CONSULTATION RESPONSE MATRIX

LAND EAST OF TYE LANE, WALBERTON

ON BEHALF OF: LINDEN HOMES (SOUTH) AND WATES DEVELOPMENTS

February 2019

Drawing Title:
DRAINAGE CONSTRUCTION DETAILS

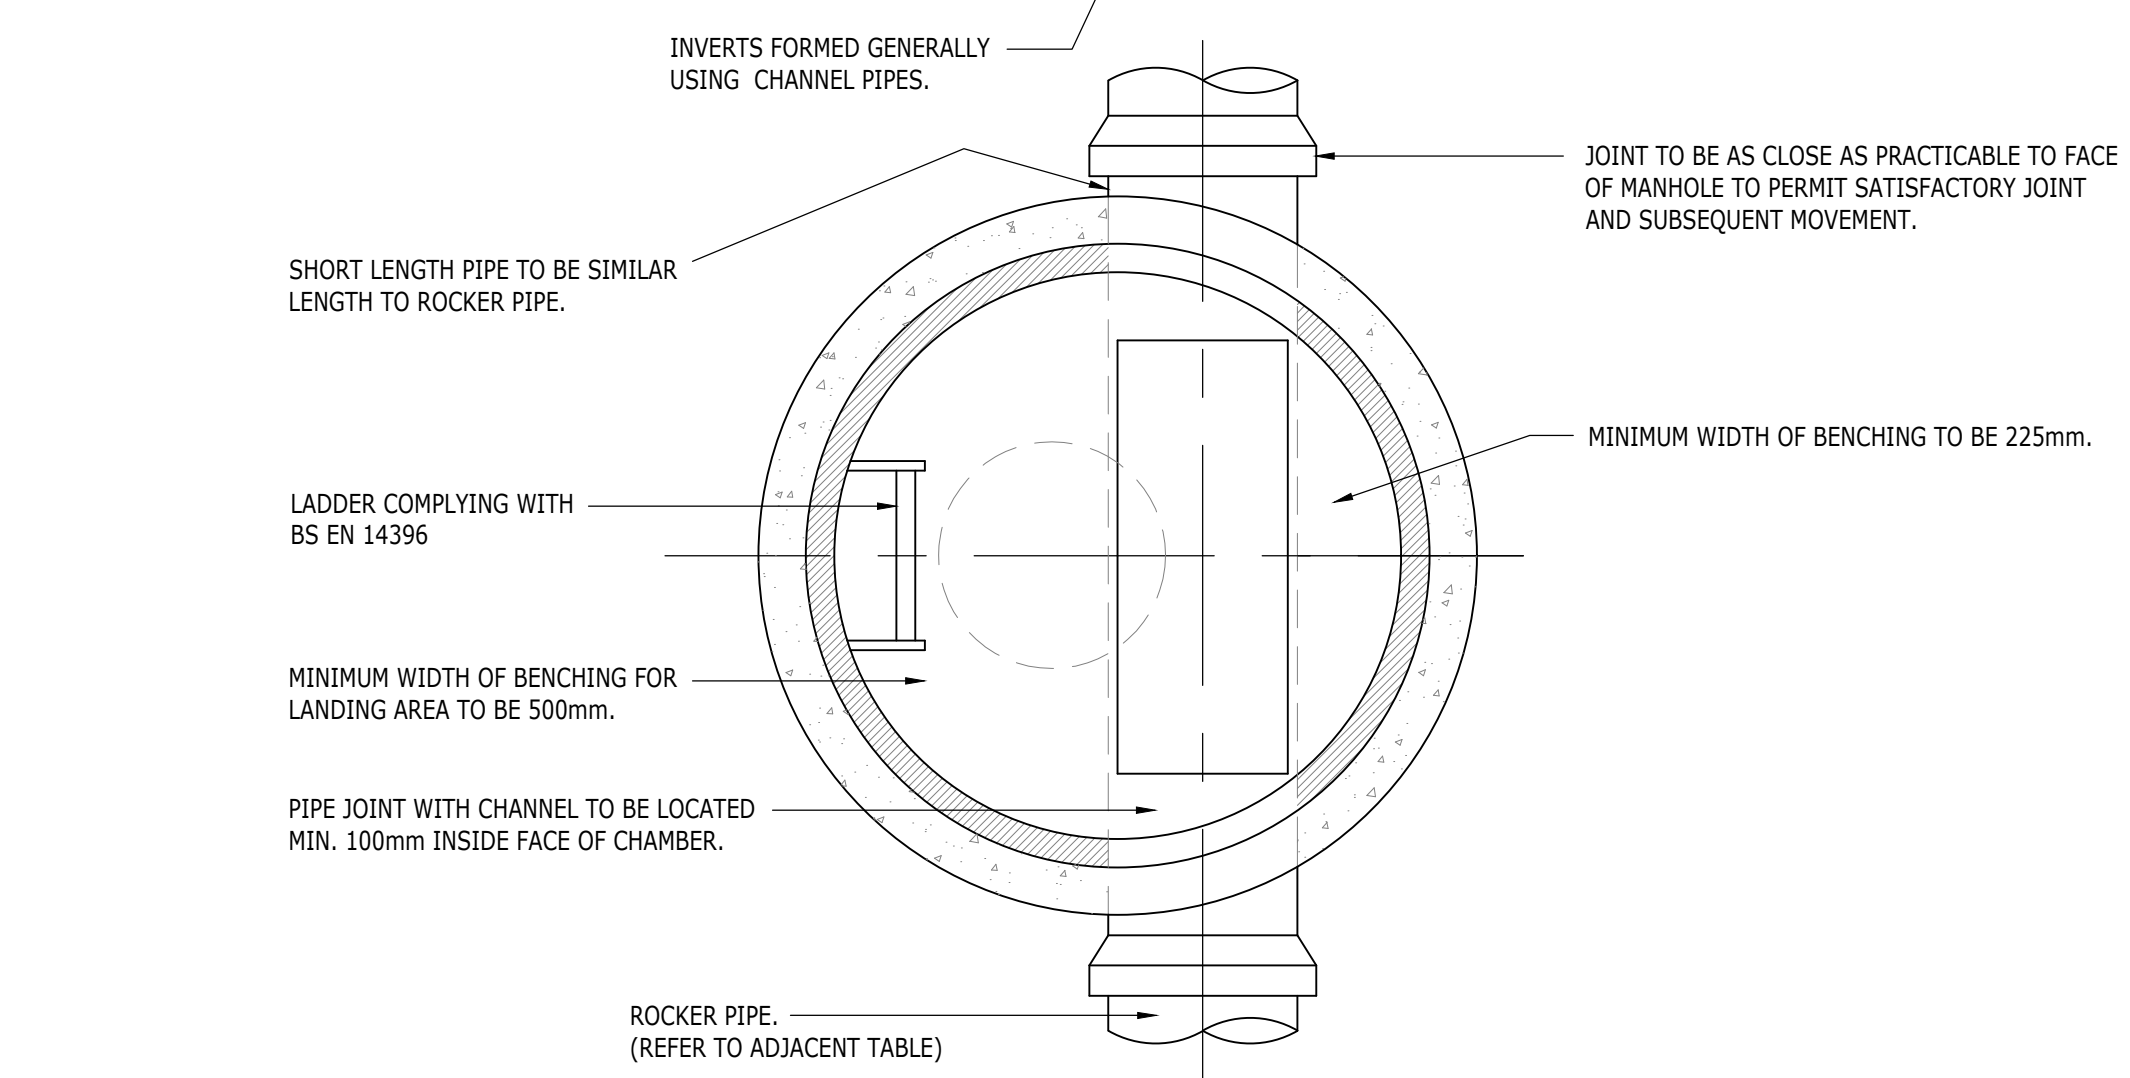
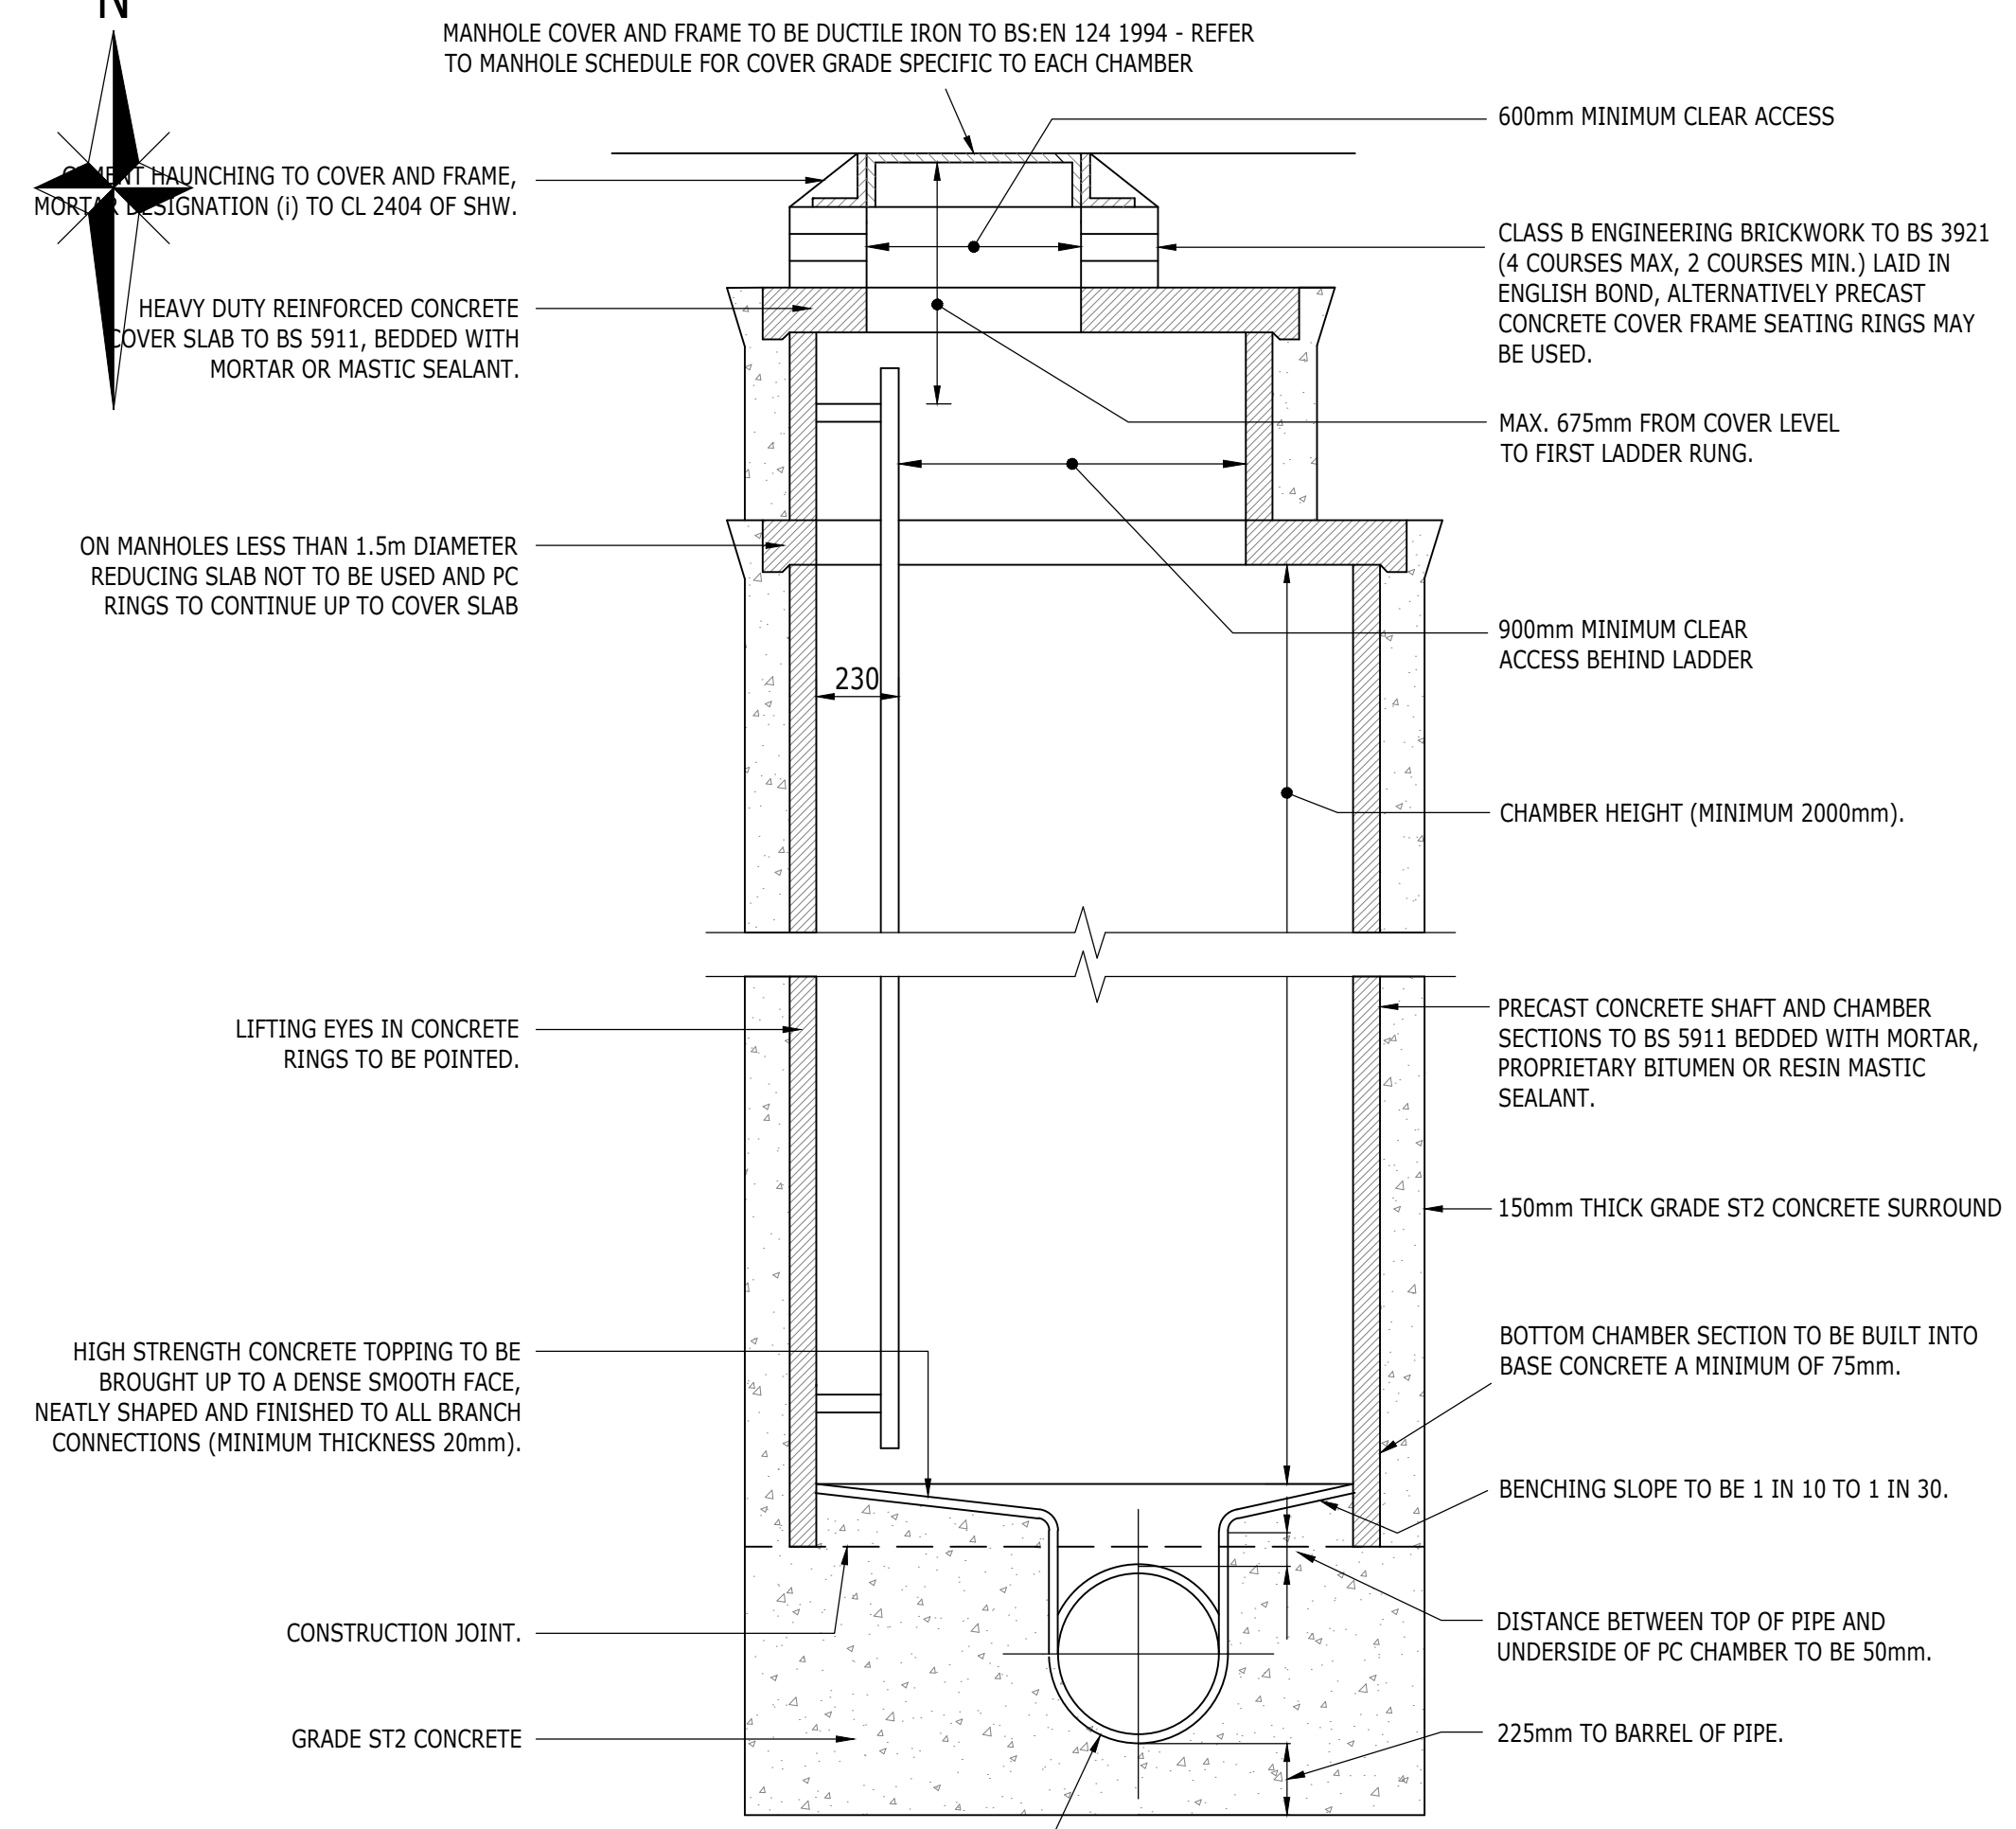
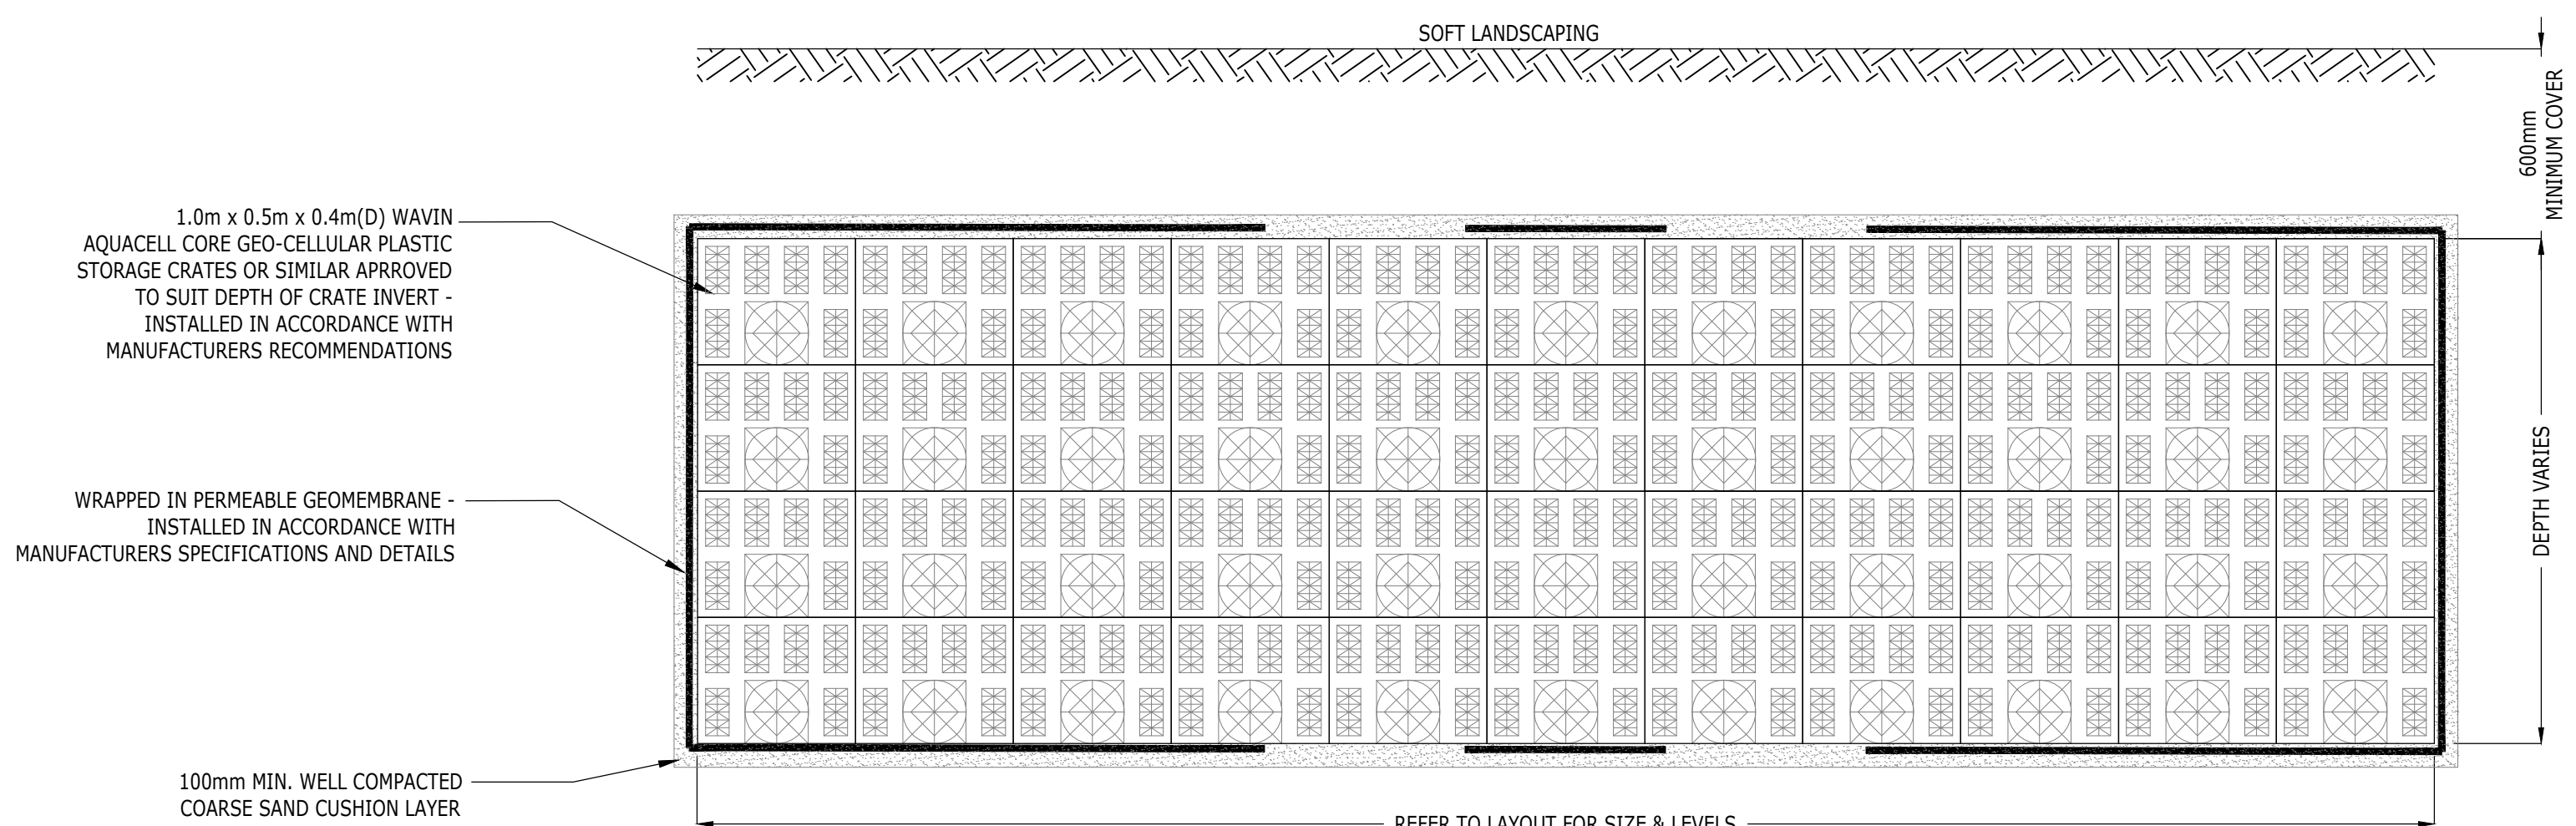
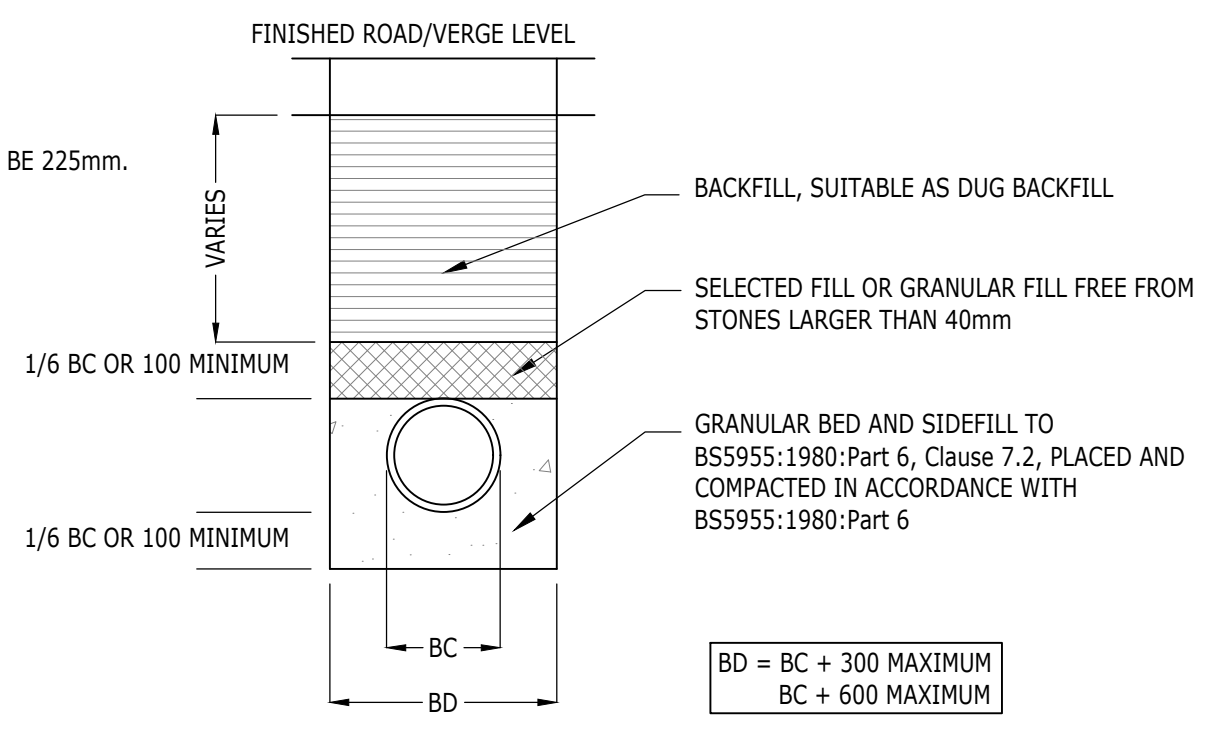
- Construction detail drawing, to include (if specified in scheme): - pipe bed and surround - Infiltrating structures - Manholes - Catchpits/silt traps - Control devices - Permeable paving - Headwalls - Exceedance flow routes Additional comments	as per sewers for adoption. as per detail already on drawing. as per sewers for adoption. as per local highway authority details. Added a typical orifice plate detail. as per typical detail added to General Arrangement Plan as per sewers for adoption. Added to plans Discussed and to be addressed through the planning condition submission	
Mark Warwick (Tree Officer)	Commented on the proximity to the TPO trees	Footpath re-aligned to sit outside the RPA to T38 The informal southern link to Tye Lane is now a 2m wide tarmac path Northernmost pedestrian footpath re-aligned to now sit outside/alongside its southern boundary
